Lead Local Flood Authority

Date 27 November 2025

RE: WA/89/25/DOC – Lower Farm, Yapton Lane, Walberton

Following a review of the submitted documentation, we are **unable to recommend the discharge of Conditions 3, 4, and 5 at this stage.**

TITLE Site Layout - Proposed Surface Water
Drainage Sheet 3 Of 4

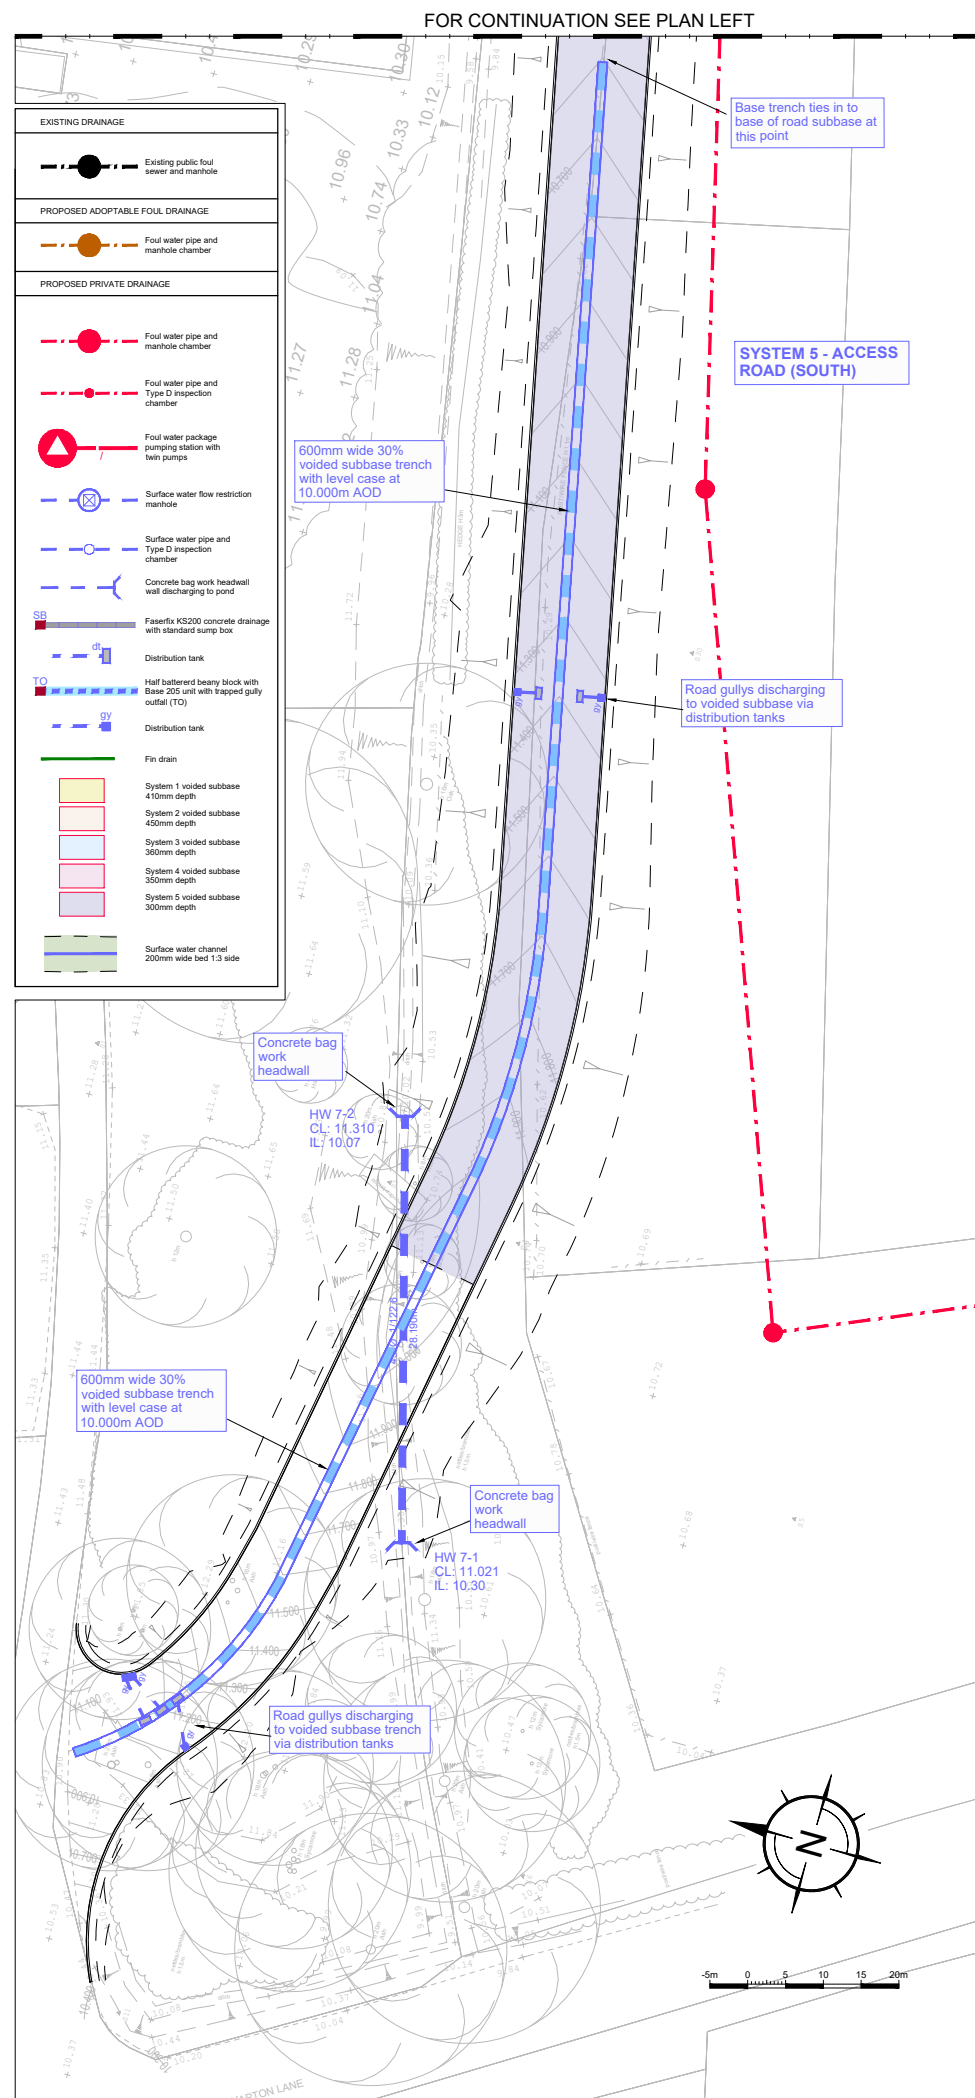
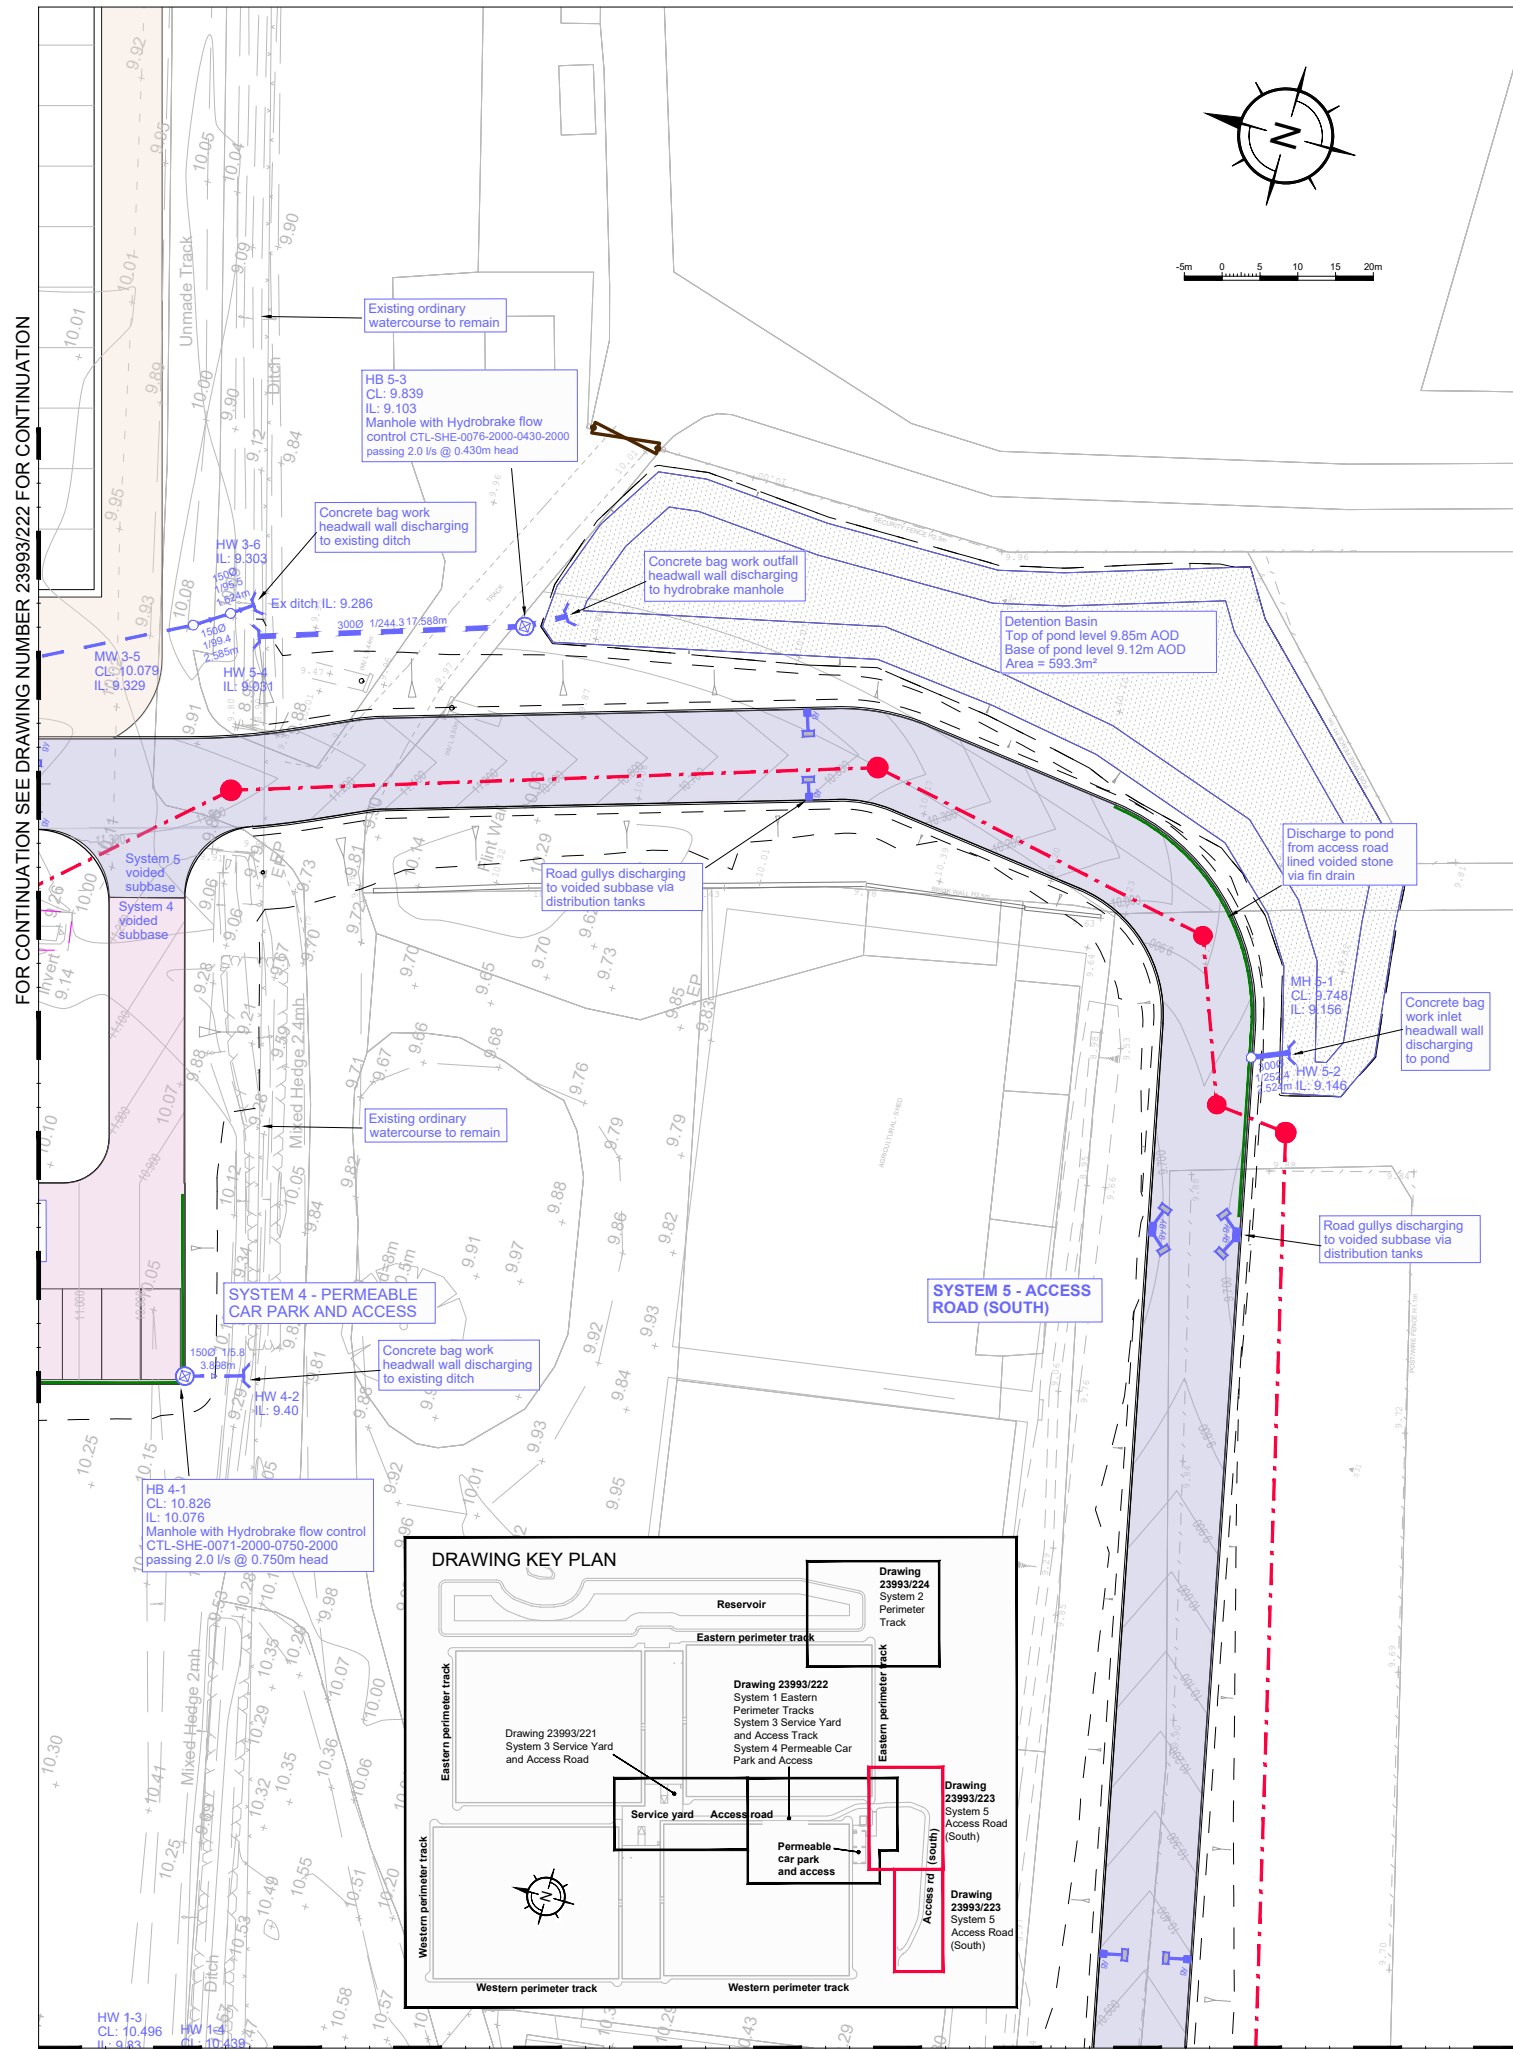
The combined discharge must not exceed QBar, therefore the proposed increased discharges for systems 4 & 5 to manage blockages must either be reduced to QBar or off-set by a reduction to one of the other systems draining to the same watercourse.

CLIENT	
Agriculture Investments Ltd	
PROJECT	
Lower Farm, Yapton	
TITLE	
Construction Details Headwalls and Hydrobrakes System 1	
DRAWN	PROJECT NO
M Pacifico	23993
DATE	NOV
1 Nov 2024	
ENGINEER	CHECKED
S Magowan	
SCALE	SHEET NO. REV.
1:200, 1:25 @ A1	521 -

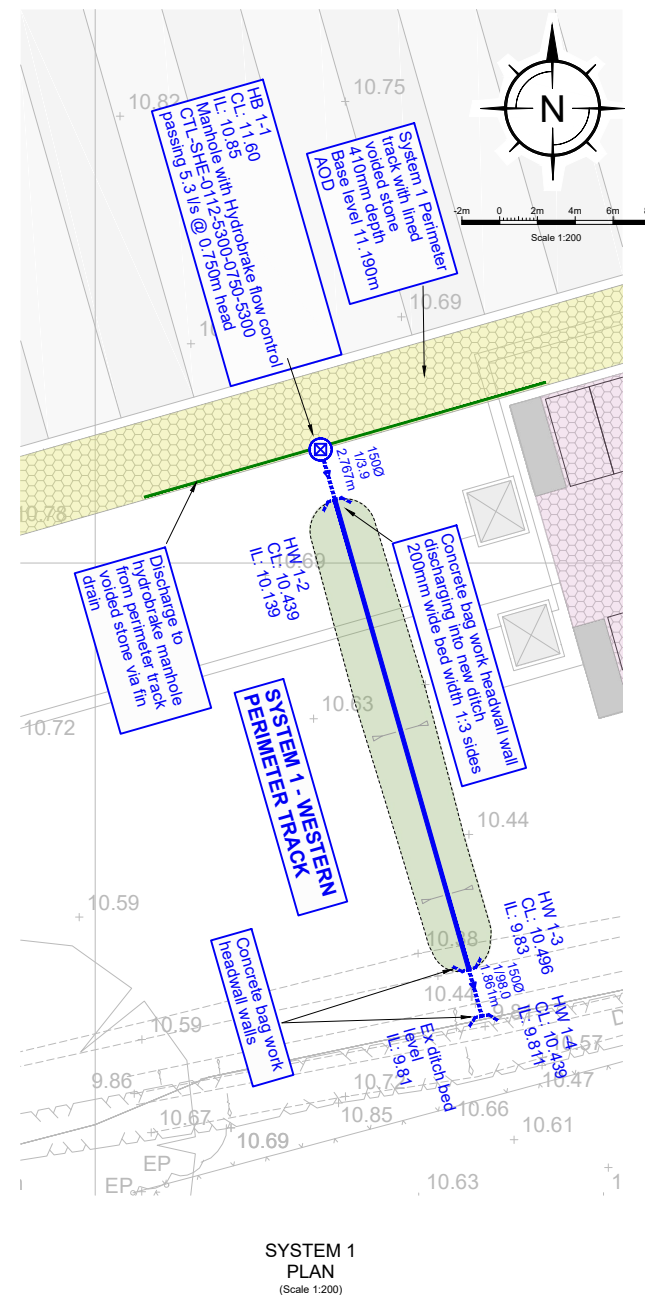
- Comprehensive **cross-sections of all key SuDS features**.
- Consistency with approved layout plans and compliance with the drainage hierarchy.
